UTS Central Project
DA Section 96
Response to feedback

University of Technology Sydney

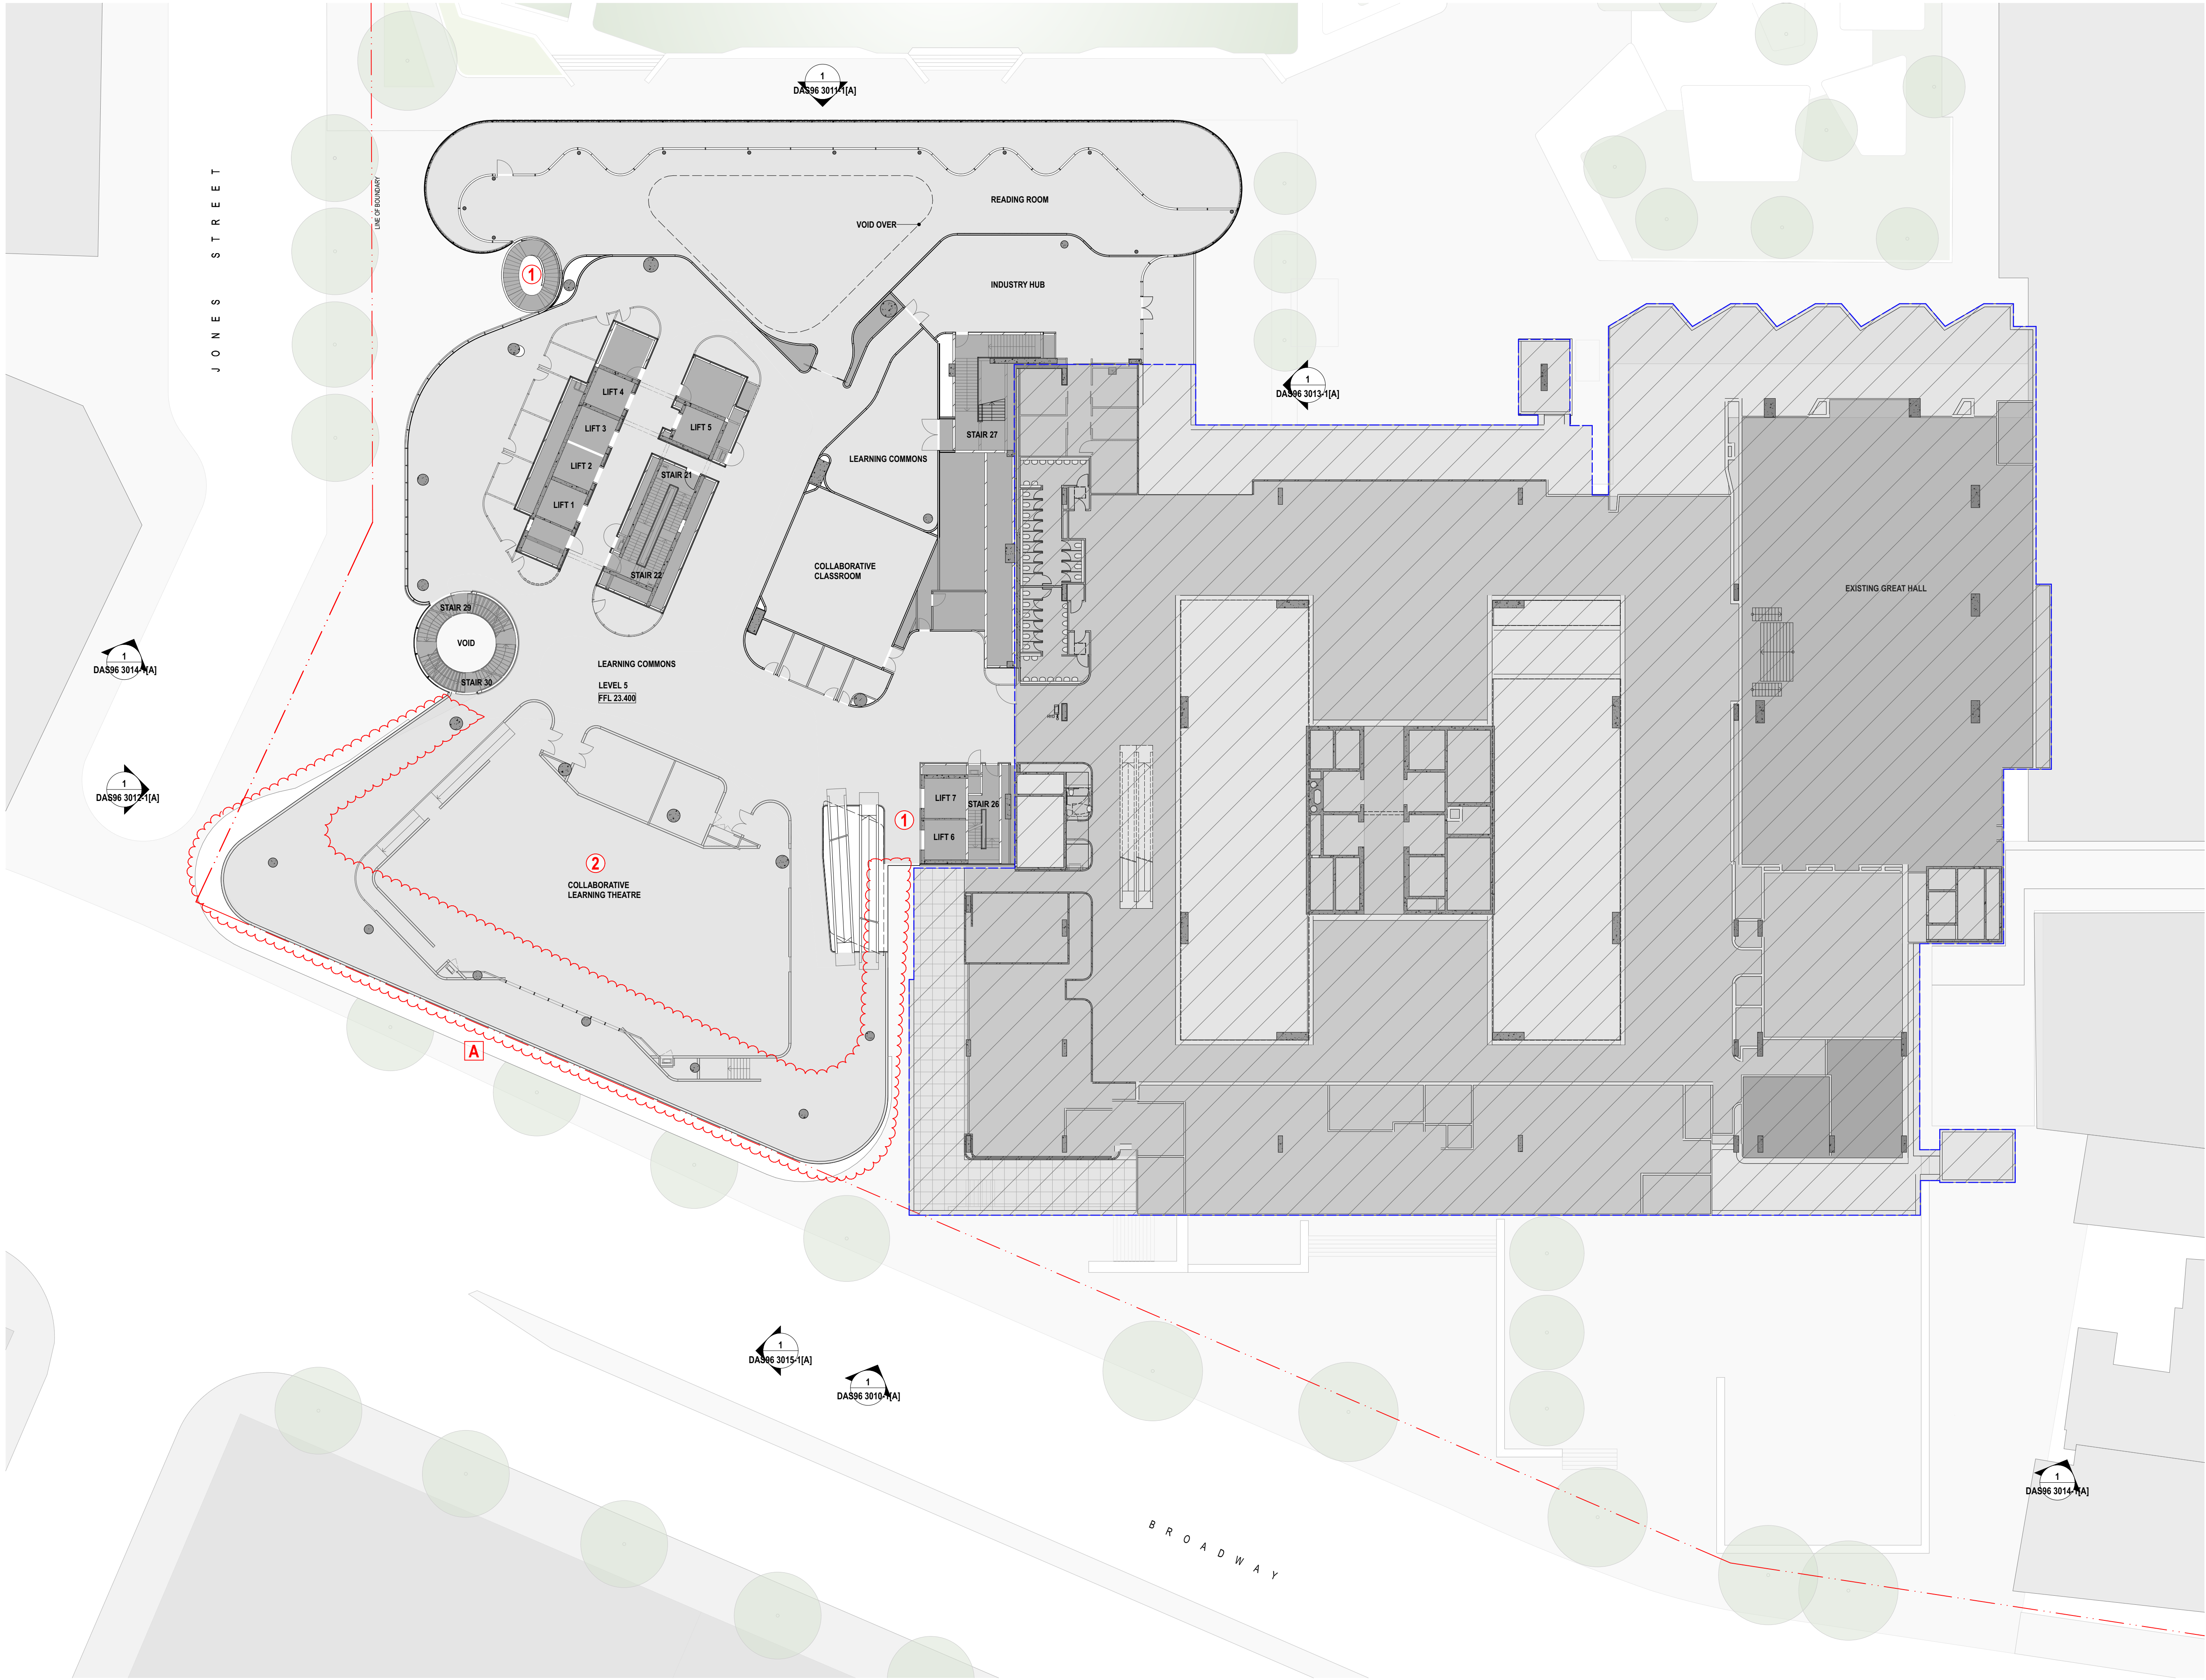
Clarification should be provided in relation to conflicting information regarding the Collaborative Learning Theatre, which appears to have been replaced by three single storey General Teaching Spaces. Further justification and detail is required to support this modification, including ceiling heights, program, entry and circulation and capacity.

Further details regarding the program for the General Teaching Spaces and the Learning Commons and how they would provide activation of the façade must also be provided, particularly whether any entry to the CLT space/s is proposed on the façade side. Without a designated circulation path around this side of the CLT, it is unlikely that this space used given the width of this space and therefore is unlikely to achieve the aim of activating the façade.

In the DA three collaborative teaching spaces were shown on levels 5, 6 and 7. These spaces have been retained in the Section 96 submission. The only change that has occurred is the shape of these spaces as a result of adjusting their position to be more central on the floor plate and away from the facades on Broadway and Jones Street. The spaces shown in the Section 96 retain the same proposed ceiling heights, programme, circulation and capacity.

Locating the Collaborative Learning Theatre (GTS) more centrally and away from the façade on Broadway and Jones Street provides a place on these floors, adjacent to the façades, for Learning Commons previously not provided for in the DA. This generates the opportunity for greater student use and activation which would be clearly visible from Broadway and Jones Street. This opens up the Jones Street and Broadway corner to allow students to make the most of the this space as a view corner.

Provision has been made for greater access to the GTS on the north side and on the south side (Broadway façade side) to more evenly distribute access to and from the GTS and therefore further activating the façade along Broadway and Jones Street.
